Ribble Valley Borough Council  
Housing & Development Control

Application no: **3/2023/0444**

Address: **Healings Farm West Bradford Road Waddington BB7 3JE**

Proposal: **Prior notification for the demolition of existing workshop building and replacement with one new two-storey dwelling with basement and rooms in the roofspace, including landscaped gardens, access and parking.**

Site plan as proposed 1:500 @ A3

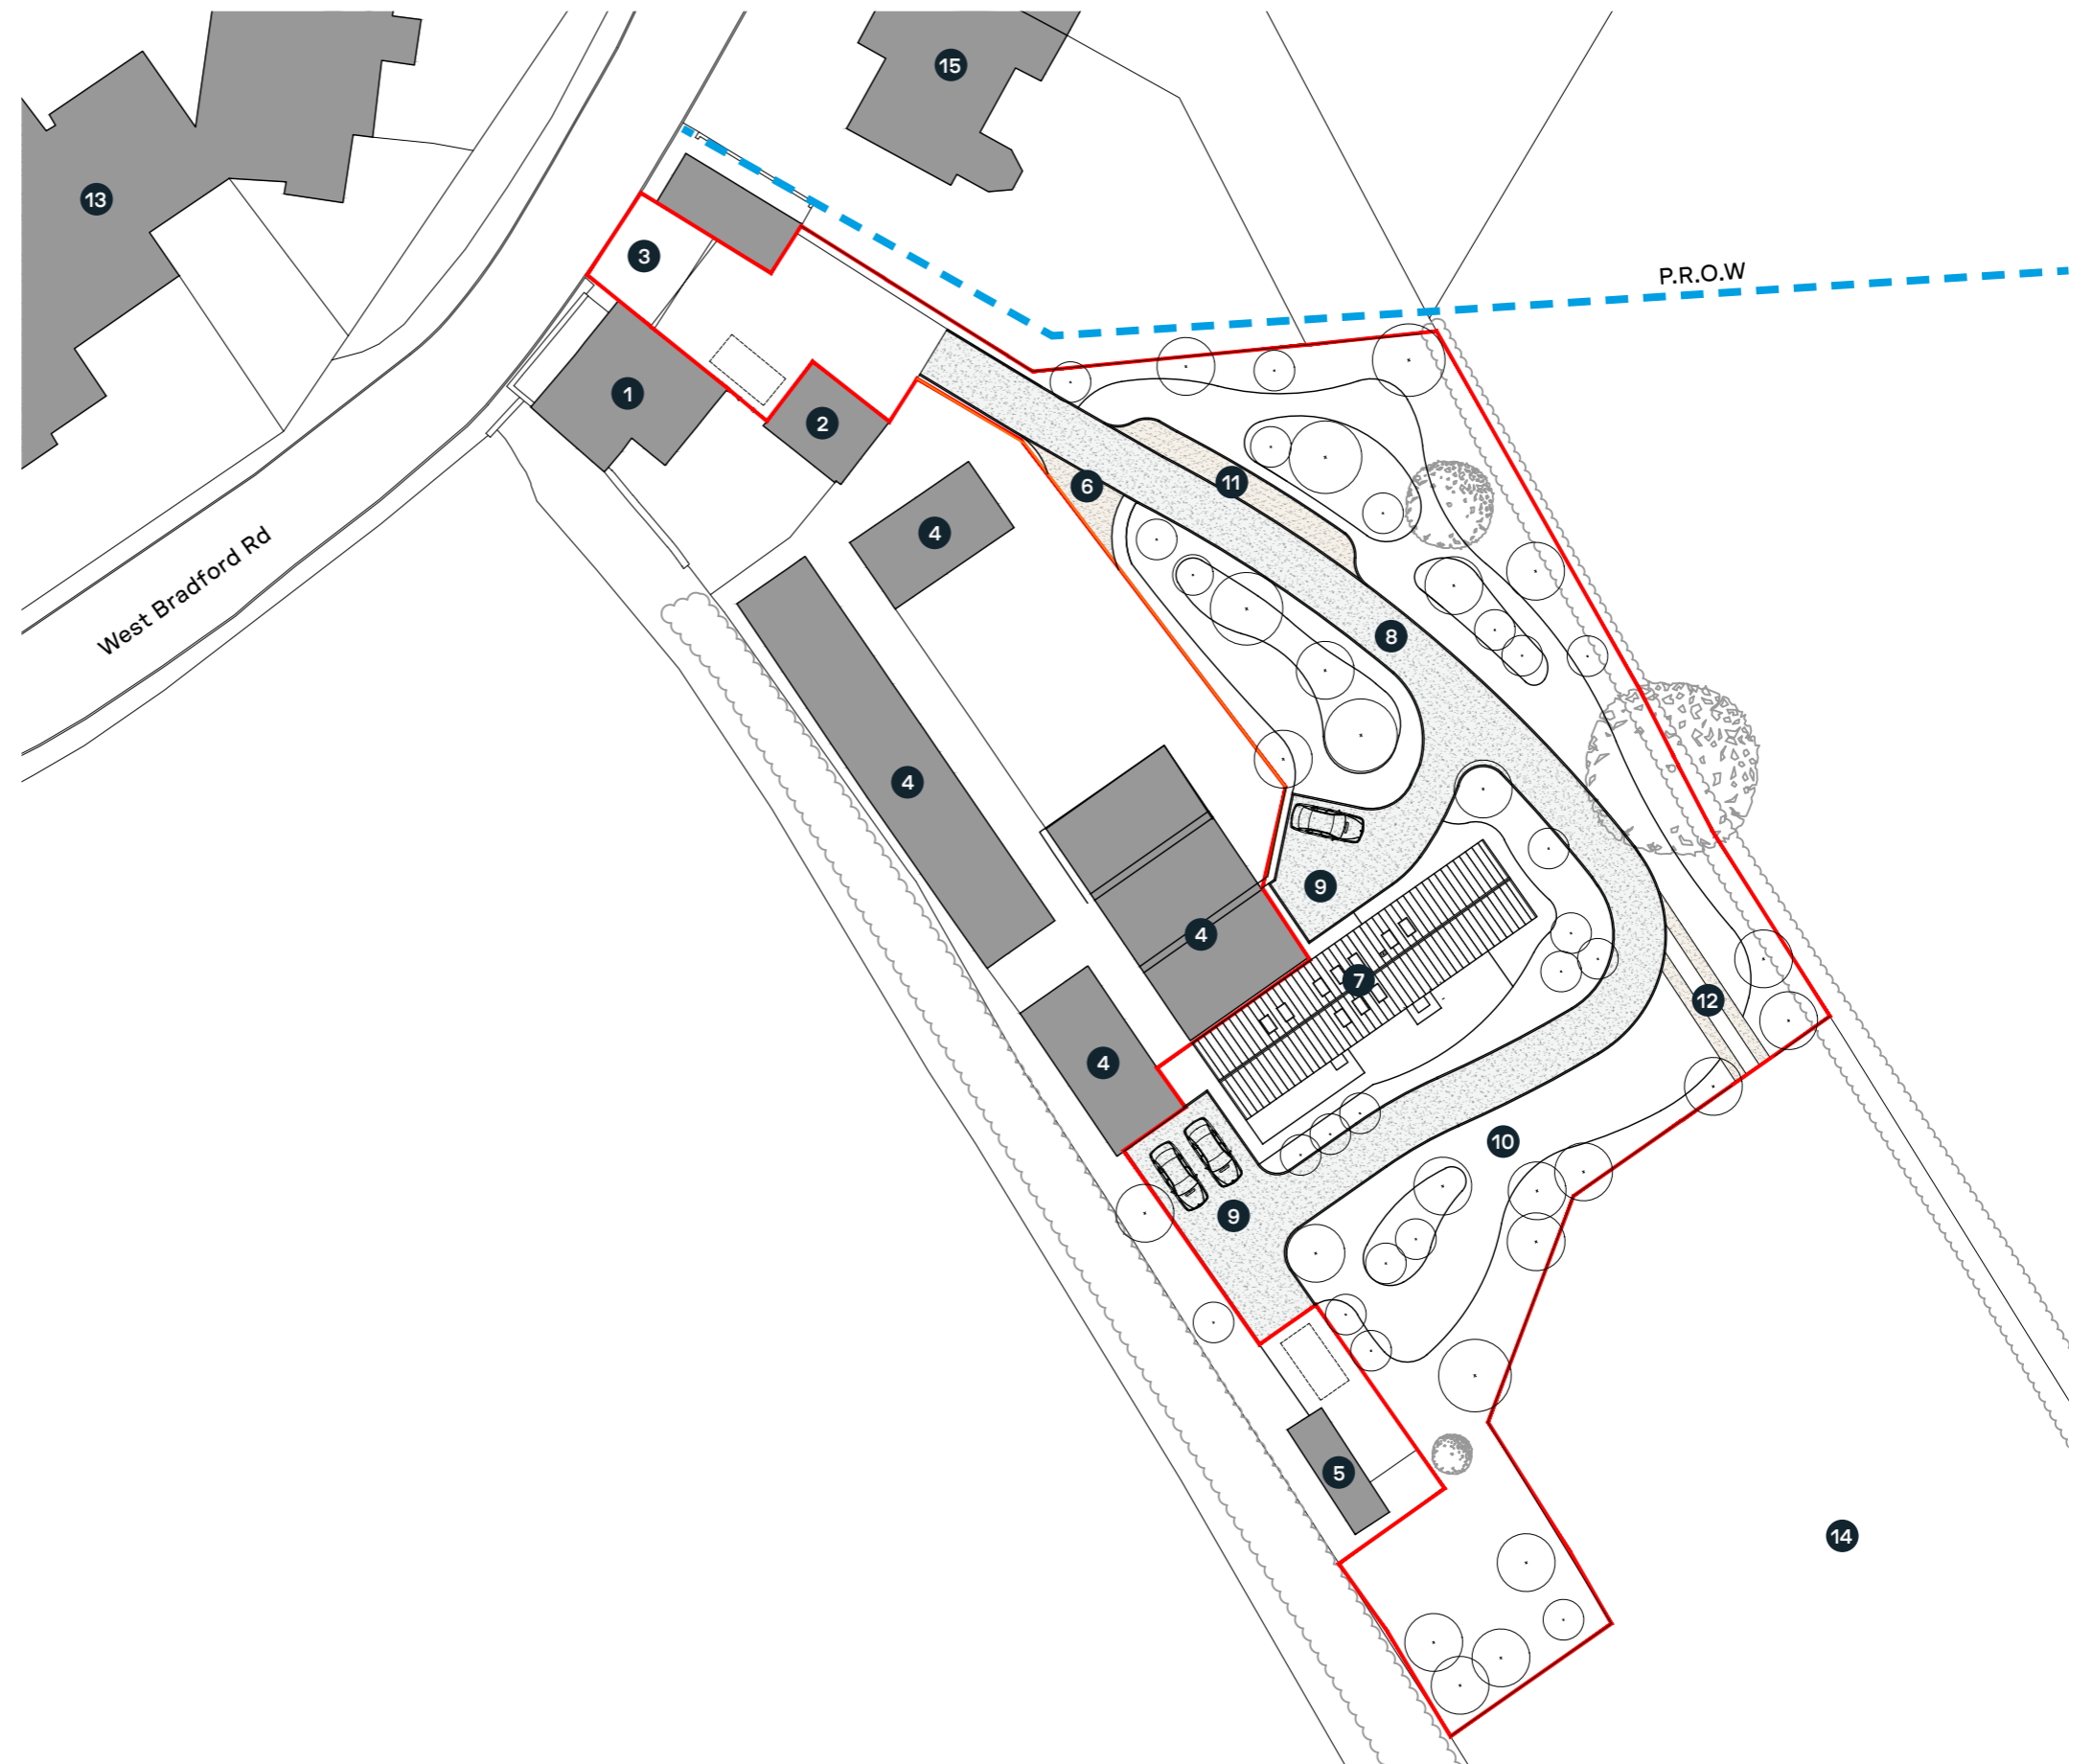
However, while the LHA welcome the formalisation of the access track, the LHA require the track to be a minimum of 3.5m wide for the full duration of its length and a passing place should be implemented along the track. The dimensions of the passing place should be 2m wide by 15m in length, given the size of the vehicles which will use the track on a day-to-day basis.

The LHA require a parking plan of the existing dwelling to be submitted, which is located opposite the proposed dwelling, to ensure that the proposal will not displace the existing dwellings parking which could conflict with the operation of the site. The LHA also require the proposed access track to be a minimum of 3.5m wide for the full duration of its length and a minimum of one passing place to be provided.

Site plan as proposed 1:500 @ A3

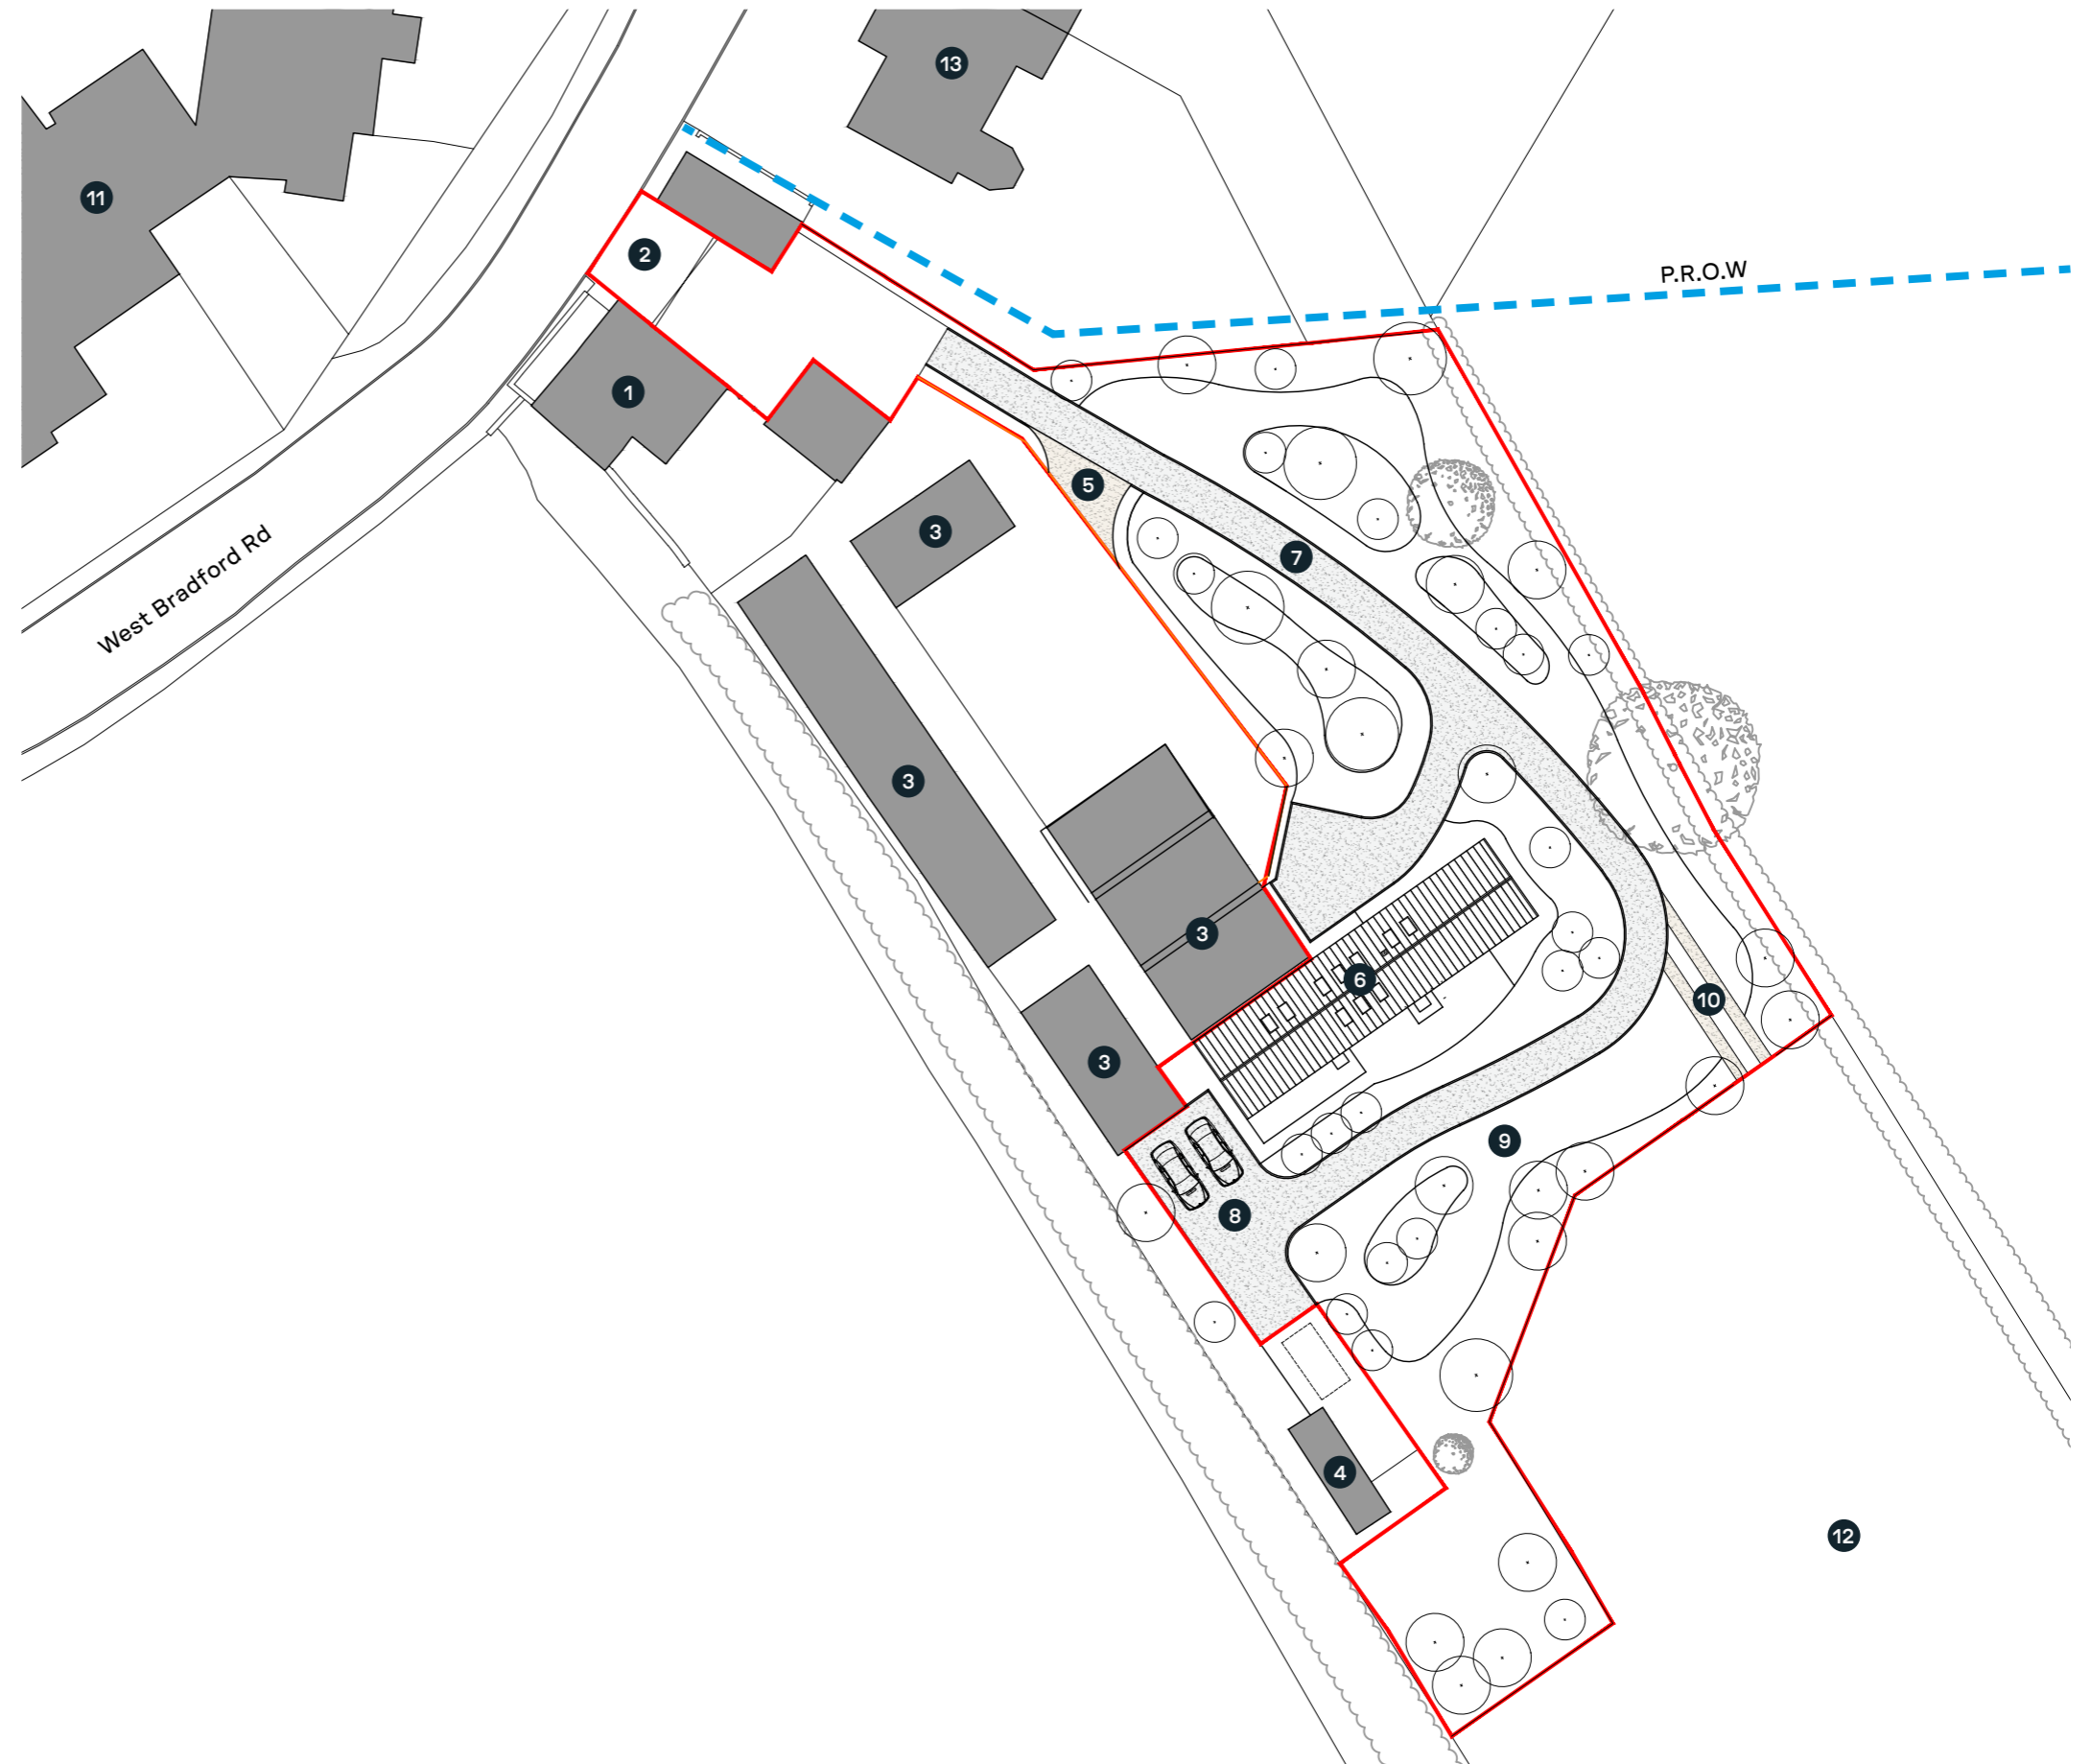
The LHA have reviewed Rural Solutions drawing titled "Site Plan As Proposed" and are aware that 2 car parking spaces will be provided for the 4 bed dwelling. This does not comply with the LHAs parking guidance as defined in the Joint Lancashire Structure Plan, which requires the dwelling to provide 3 car parking spaces.

However, before the LHA can accept any shortfall in parking at the proposed dwelling, the LHA require information regarding where the existing dwelling, which is numbered 4 on the plan, park. The LHA require this because the LHA do not want to displace the parking of the existing dwelling, which could cause conflict with the operation of the site. Therefore, the LHA require a parking plan for the existing dwelling.

Furthermore, the LHA have reviewed Rural Solutions drawing titled "Site Plan As Proposed" and are aware that the proposal is aiming to formalise an access track which will serve the site. The proposed access track which connects to the site access and serves the agricultural field, two dwellings (including the one proposed) and a number of buildings which are used for light industrial, will be 2.8m wide.
